OBSERVATION/SUBMISSION TO PLANNING APPLICATION

Case Reference: 324113

Re: Observation to the proposed development of open-cycle gas turbine (OCGT) and generator with ancillary equipment.

Applicant: Bord Gáis Energy Limited

Purpose		PLANNING	
Title	PROPOSED SITE LIGHTING LAYOUT		
Original Scale	Design/Drawn	Checked	Authorized
1:500 at A1	RRT	SR	AJB
1:1000 at A3	Date 31/10/25	Date 31/10/25	Date 31/10/25
Status	Drawing Number	Rev	
A2	PEK3-ATK-ZZ-DR-EE-901300	0

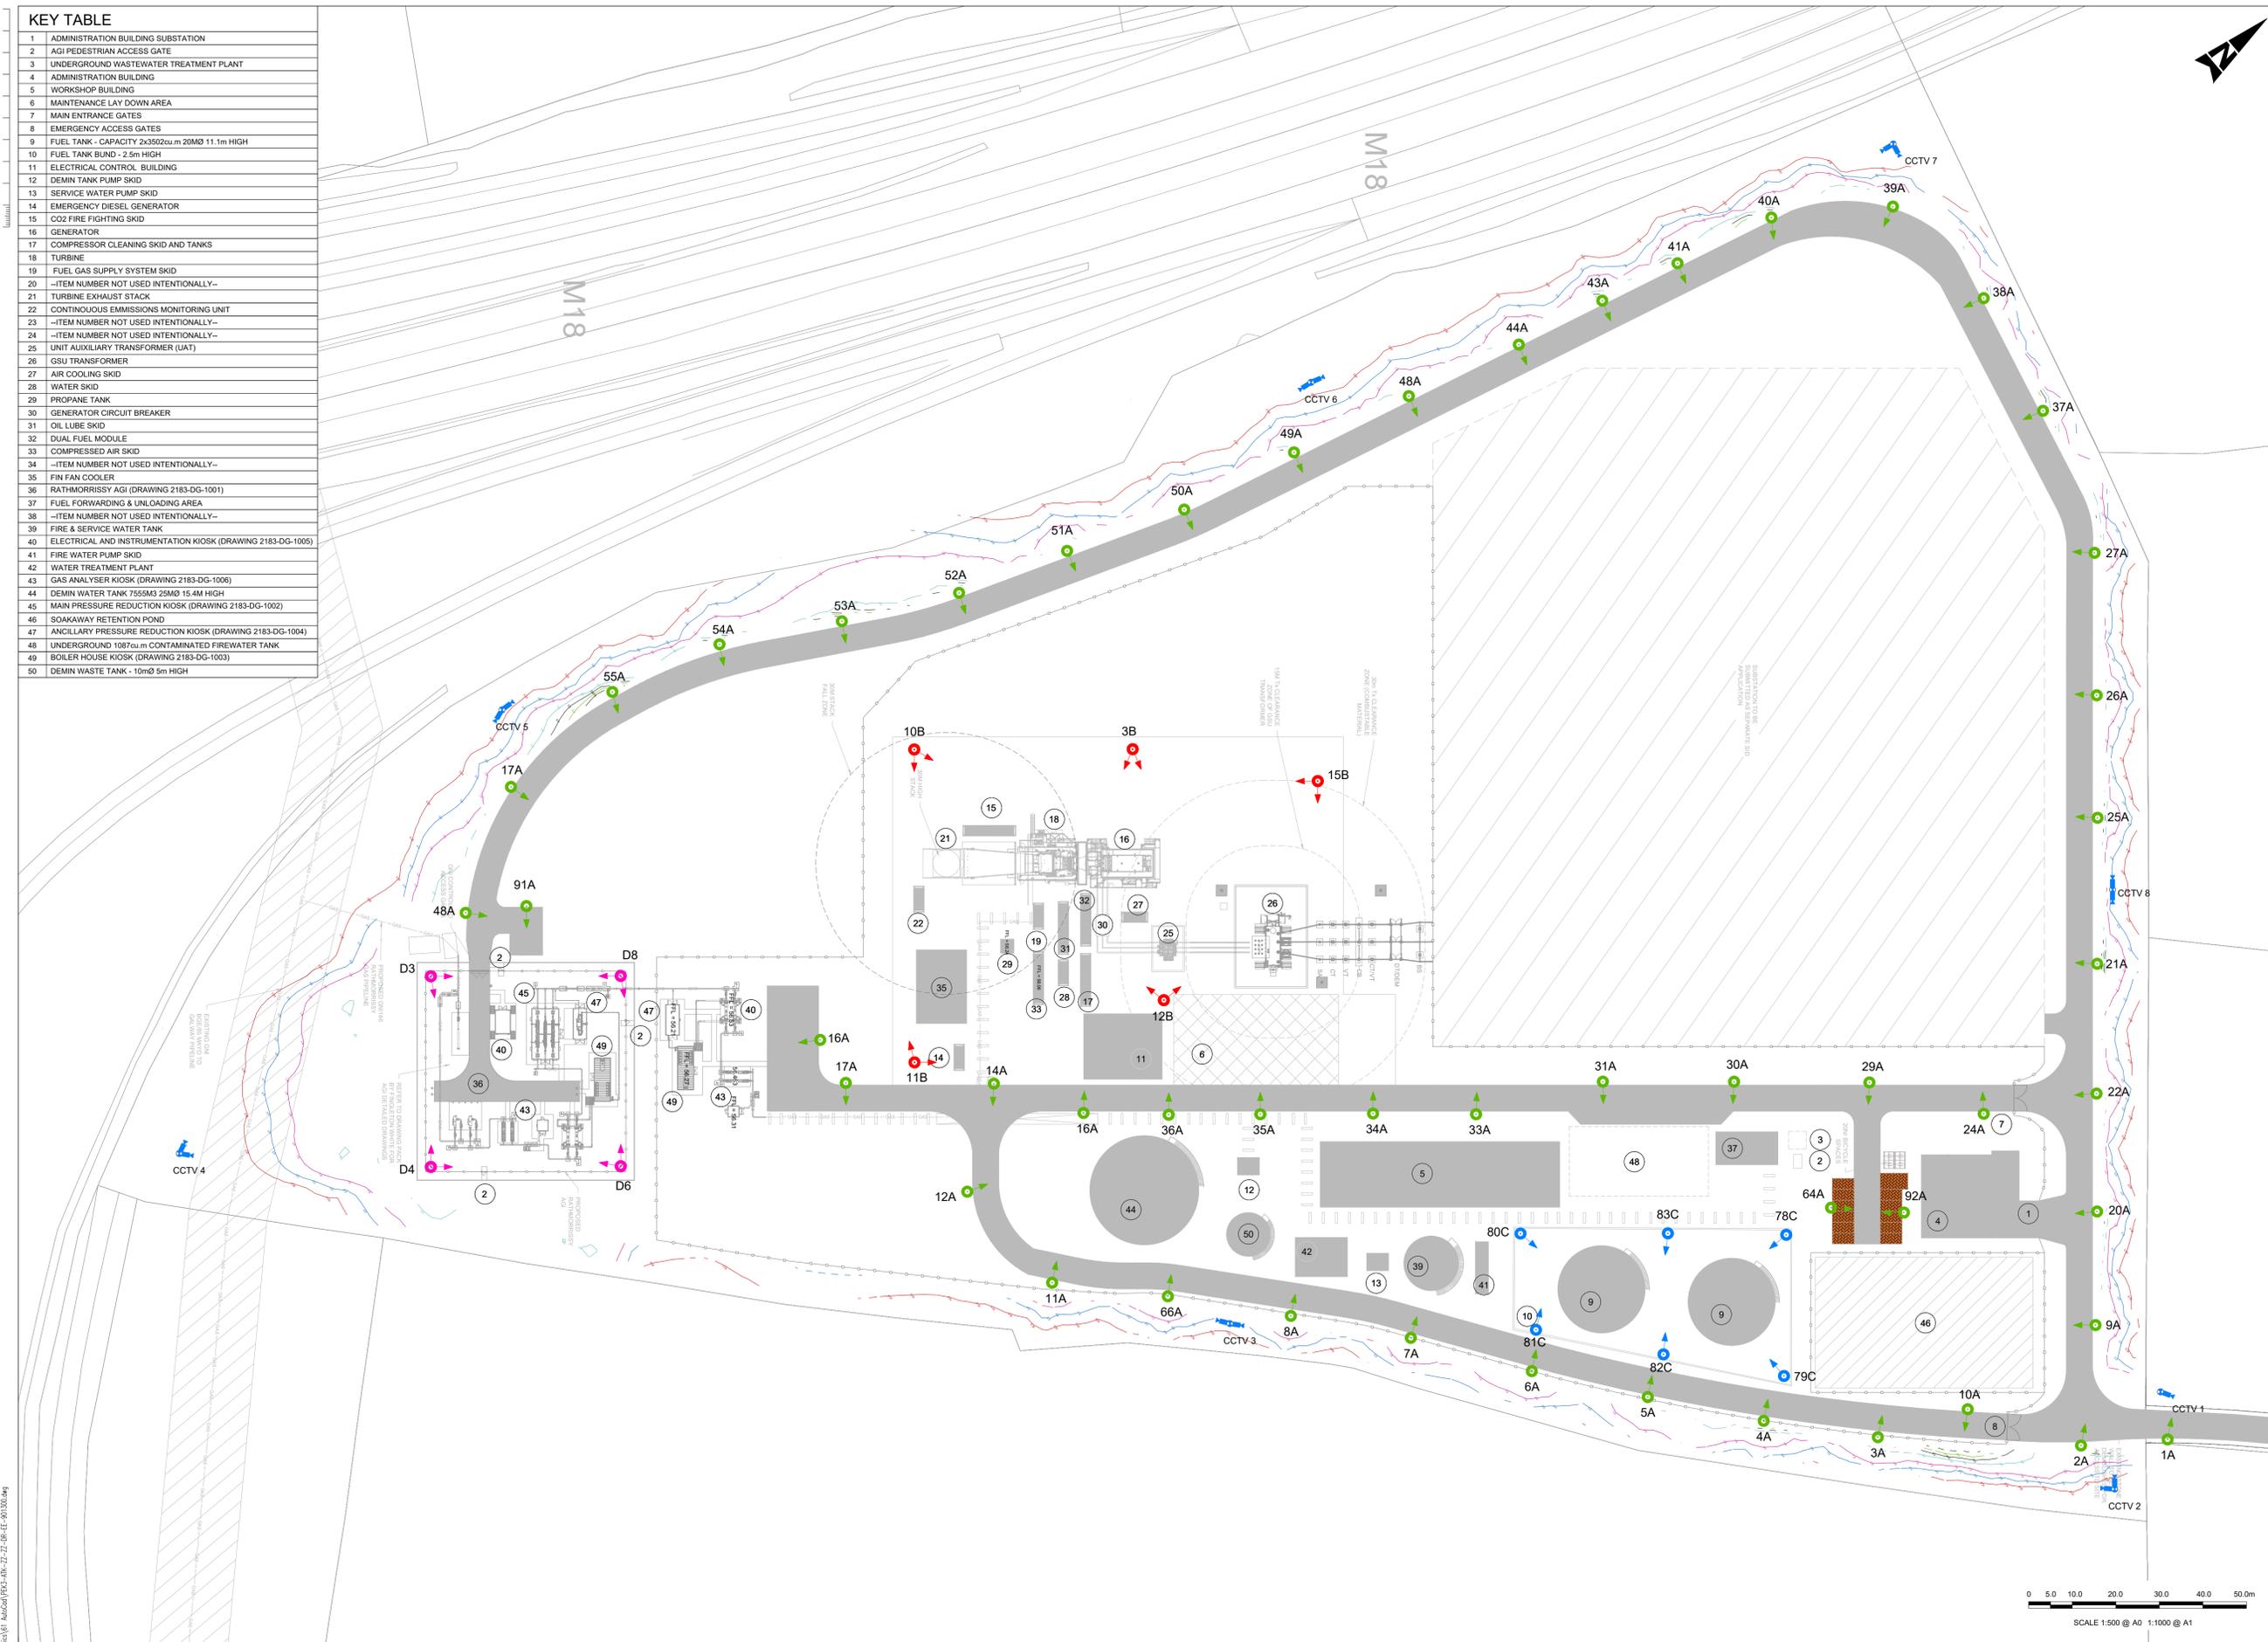
- **Light Pollution and M17 Hazard:** The site runs alongside the Rathmorrissy slip road off the M17 towards Athenry and M6 motorway. The proposal includes 18 no. 20-metre high lights and 61 no. 8-metre high lights. This unprecedented level of industrial lighting will cause severe glare and light pollution, blinding motorists navigating the roundabout and slip road at night, thereby creating a significant road safety risk.
